Letter No. **D.Dis. A3/6086/91.**

Sub: MMDA - Planning Permission -
**Construction of residential building in Door
No.9, New Tank Street at S.No.238/25,
Block No.24 of Nungambakkam Village -
Approval - Regarding.**

3. The approved plans are numbered as Planning Permit No. **A/1112/91** and 3 copies/sets of the same along with the copy of the Planning Permit are enclosed herewith for taking further action in this regard.

DEMOLITION PLAN

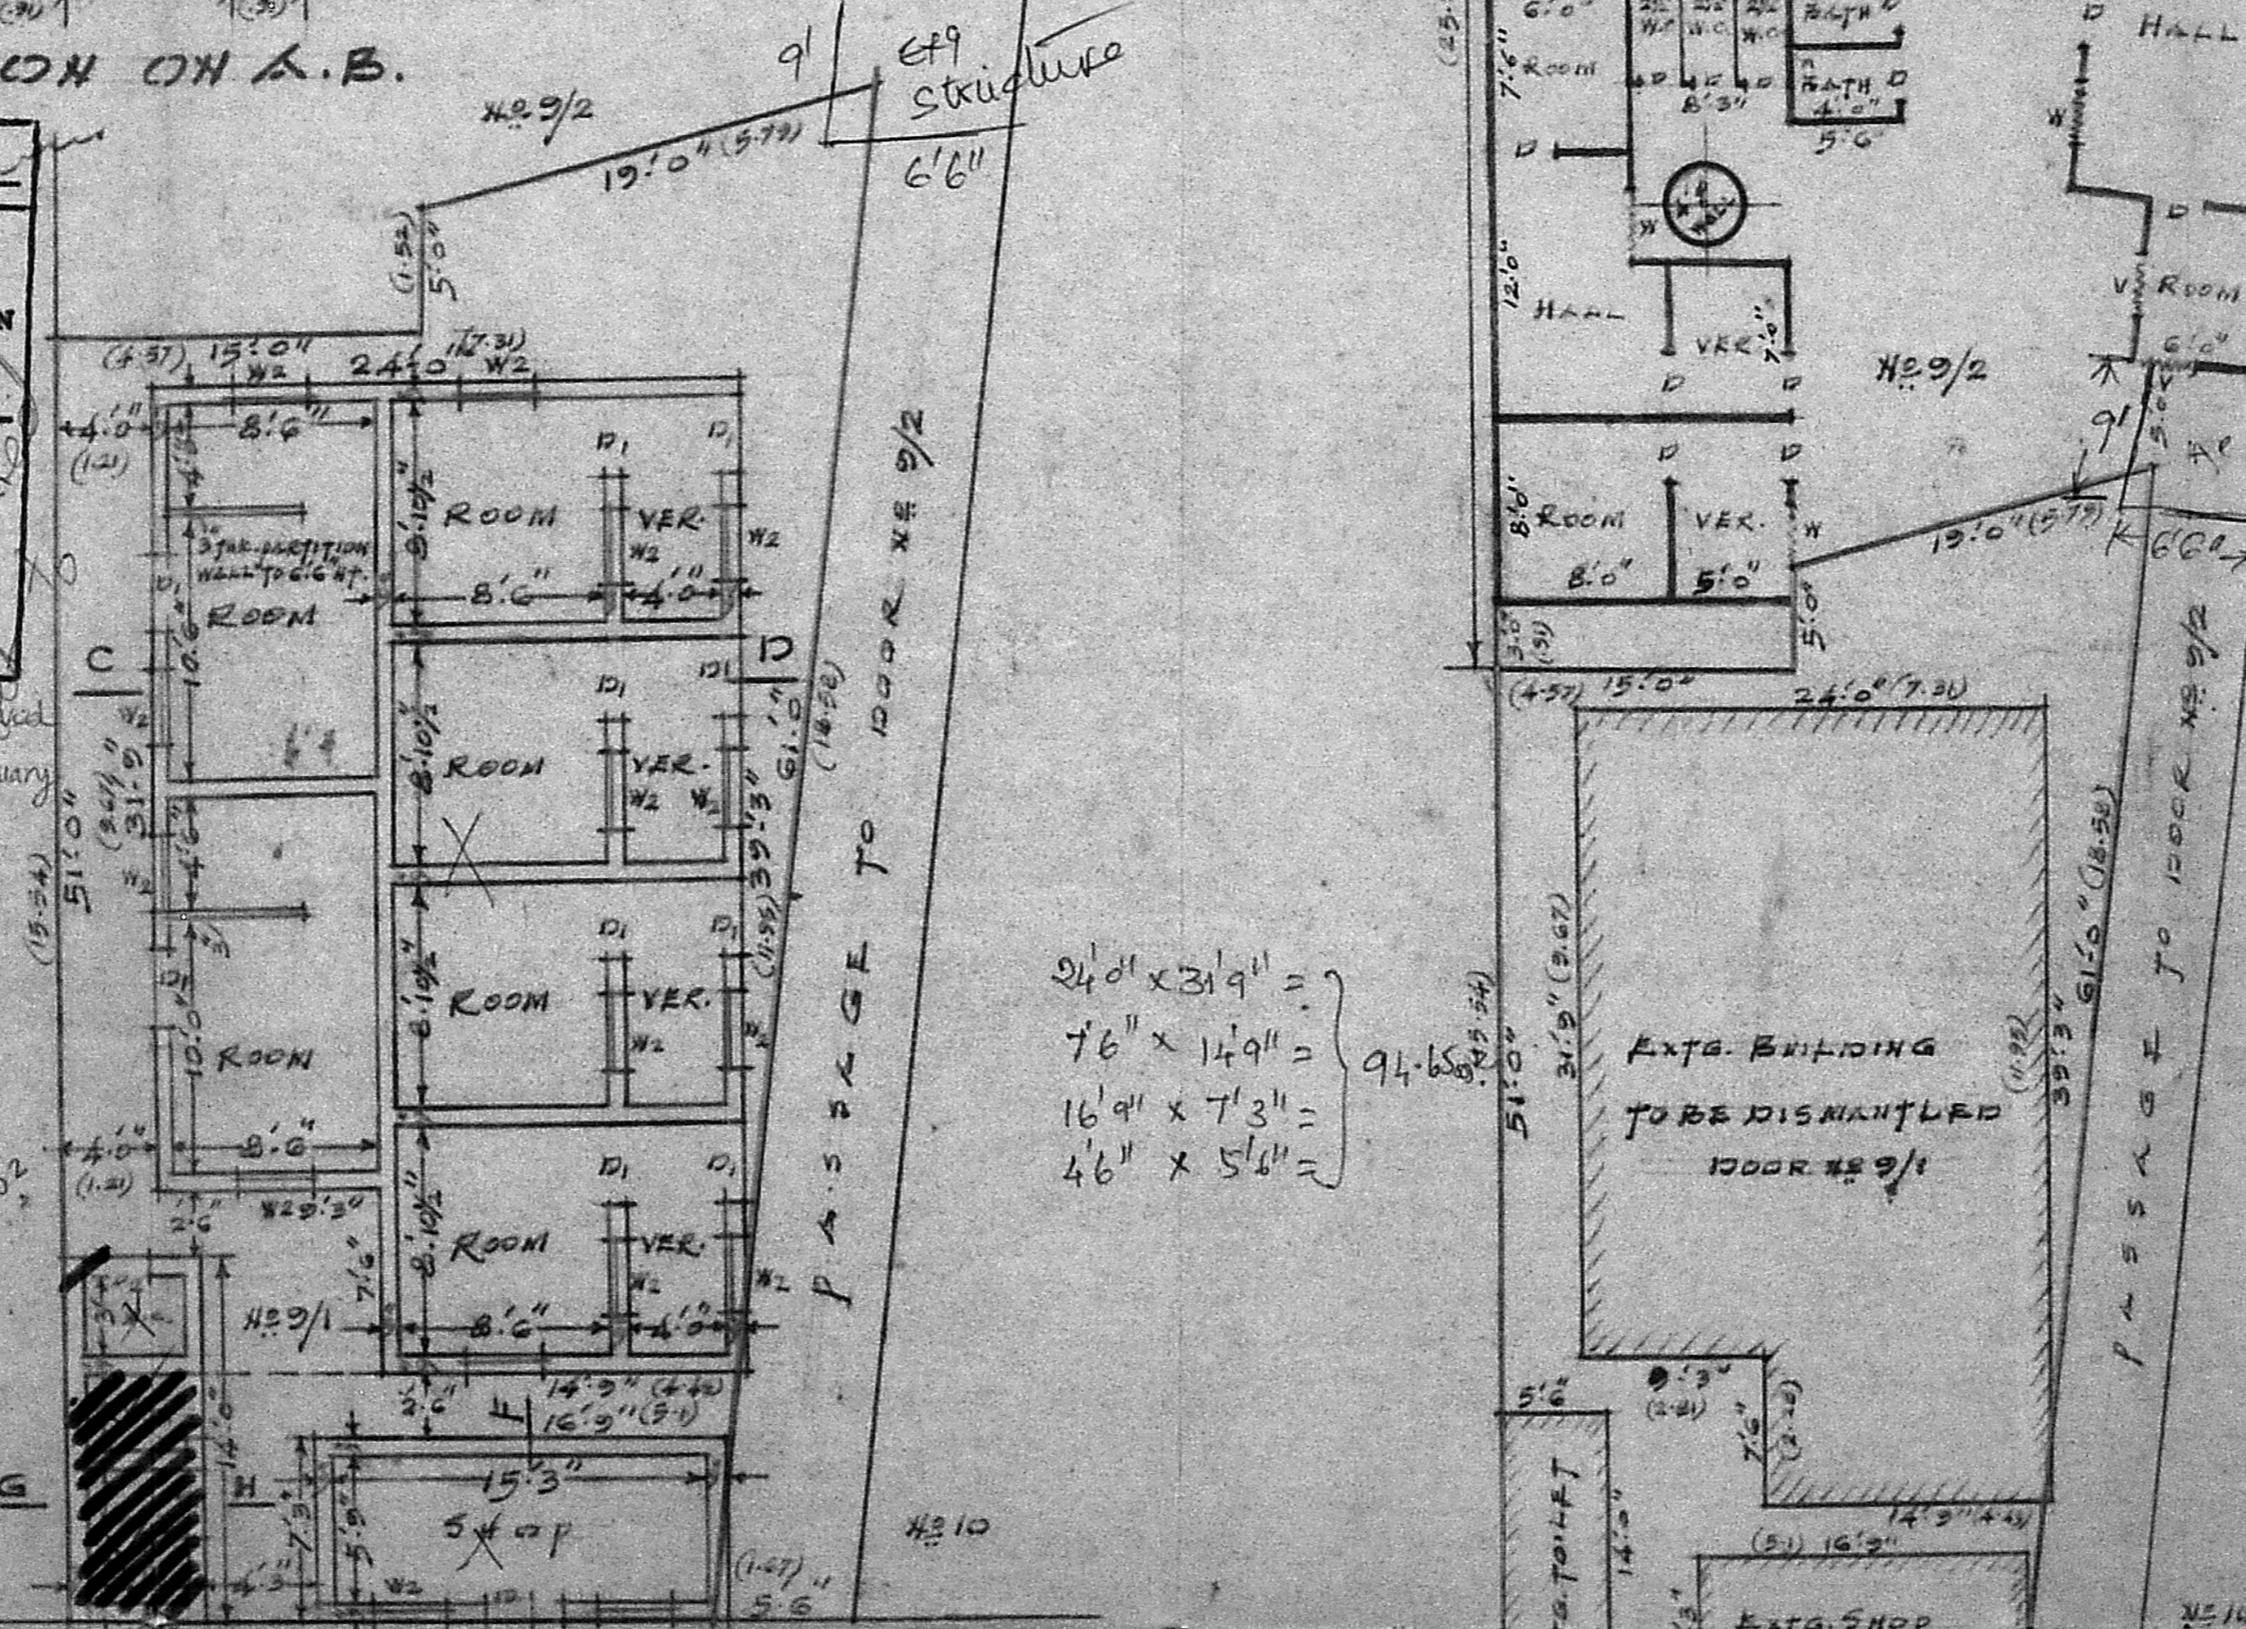
- 1) The existing strutches shown as to be demolished should be demolished;
- i) 'in the Open space within the site to the extent feasible trees be planted and the existing trees preserved'
- ii) 'it was requested to ensure that the plans for the new buildings will incorporate the approved designs for mosquito-proof overhead tanks and wells'
- iii) 'improvement charge, open space reservation charge and other charges as applicable'

RESIDUARY PLOT DETAILS
 SCALE: 1 IN. = 10 FT.

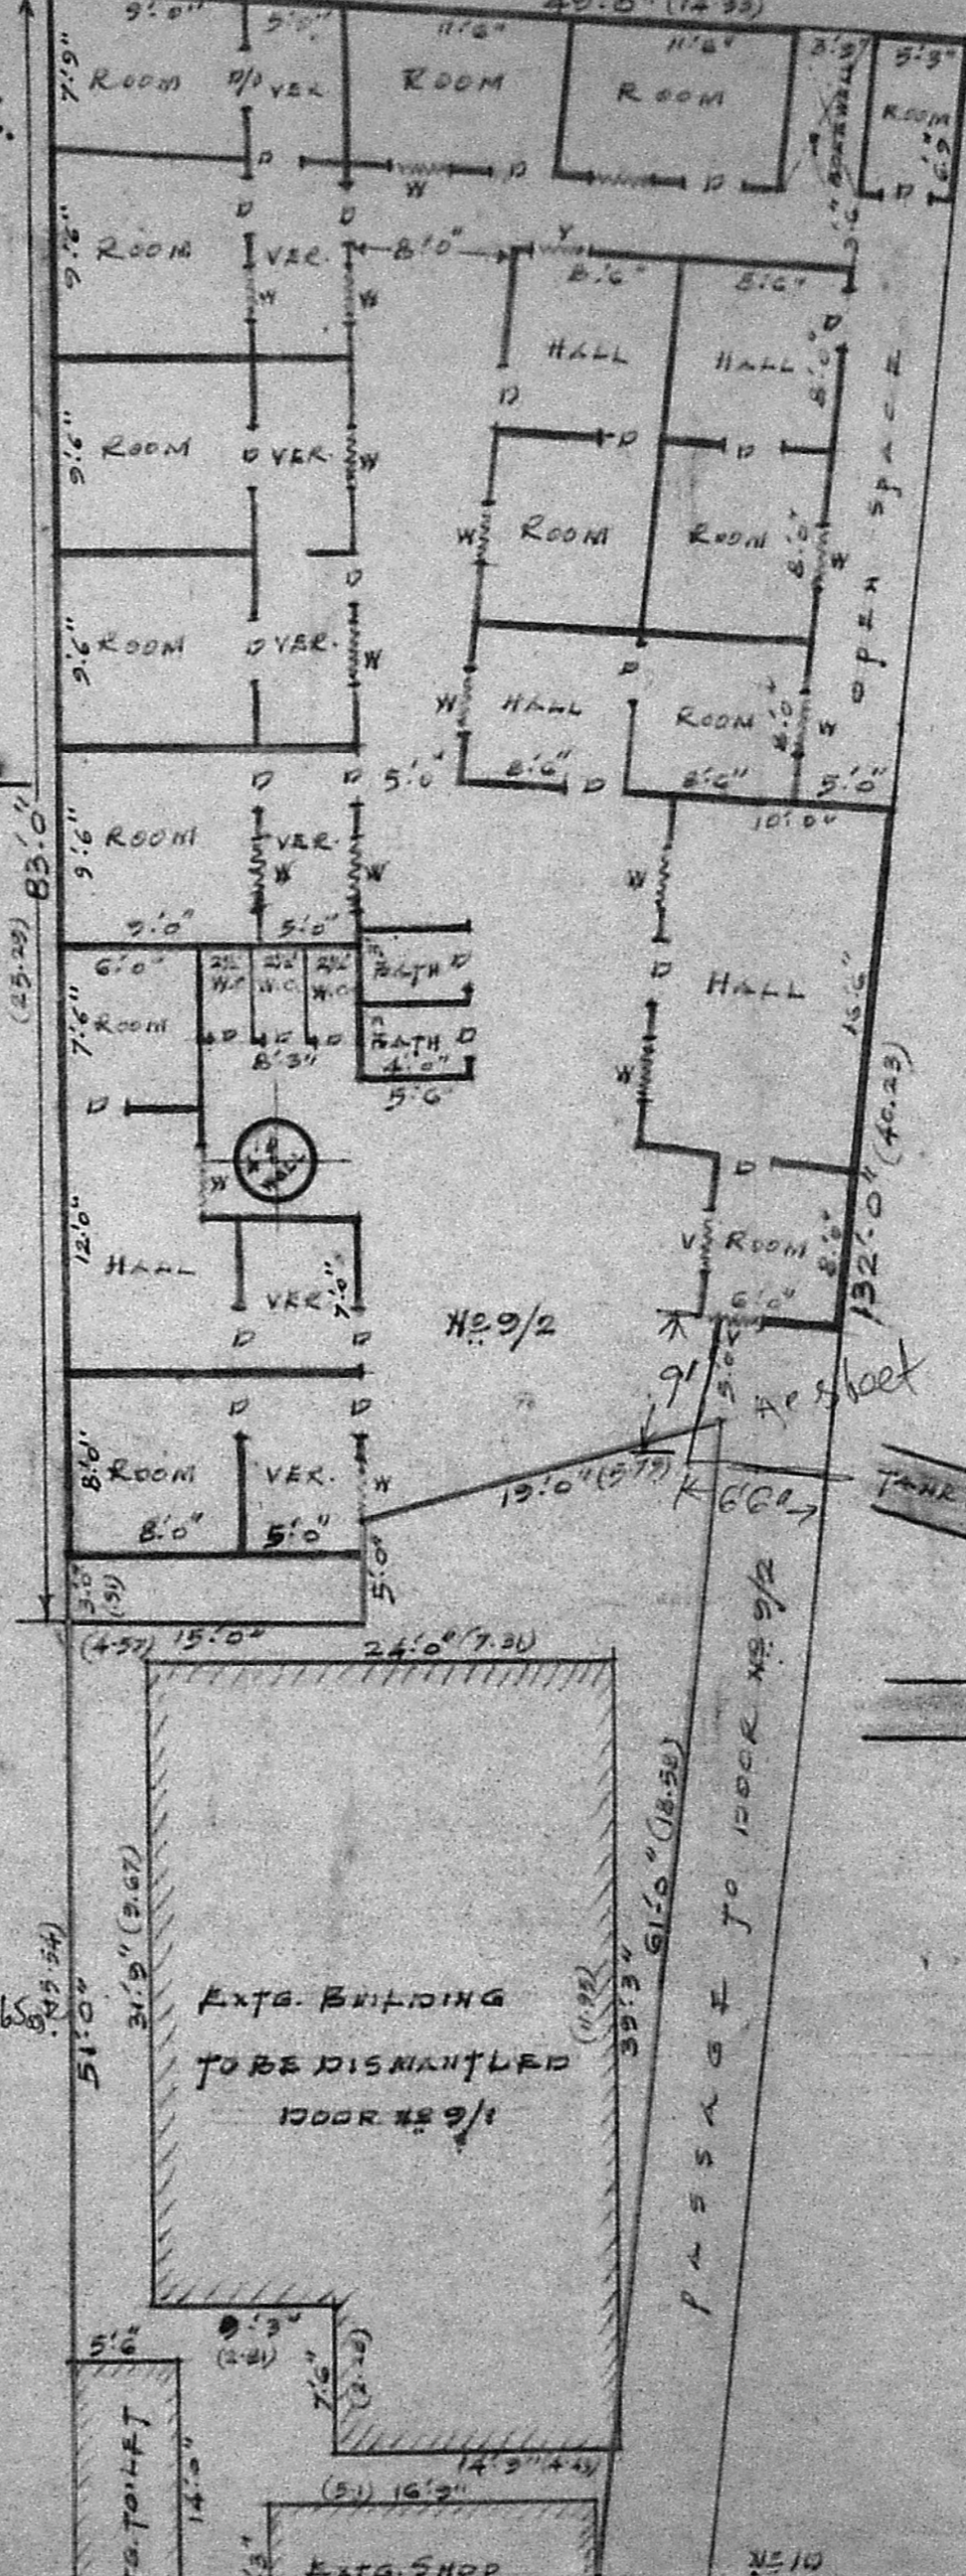
2. The revised plans submitted by the applicant directly to this office was examined and found that the planning permission for the same is issuable with a disclaimer for residuary plot a structure thereon and subject to condition that -
